From: Nick Mustoe [REDACTED]
Sent: 15 June 2021 12:16
To: Finlay Gardner <Finlay.Gardner@arun.gov.uk>
Subject: Planning Application K/16/21/HH 7 Coastal Road

I would like to supplement my existing objection to this planning application with regard to the additional one metre plus in height of the roofline and new bedrooms:

Project Coastal Road Drawing Proposed Second Floor	Project No. 2107 Dwg No. 3.102 Scale 1:100 @ A3	Rev Date Notes </
--	---	--

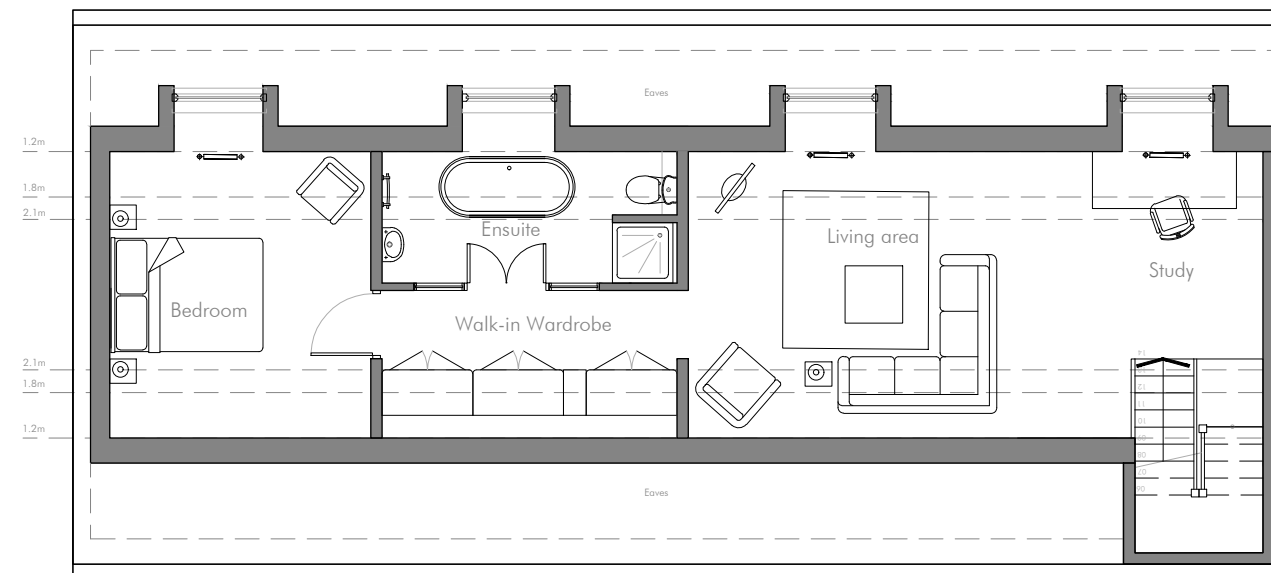
It will cause significant shadowing to my main first floor and ground floor terraces (which have seating and dining provision) as well as pose a clear invasion of privacy to both areas.

Both are used extensively and are currently not overlooked .

I would also like to add that the Parish Council has commented that they haven't objected only if there is no undue overlooking of neighbouring properties which is obviously not the case given the above.
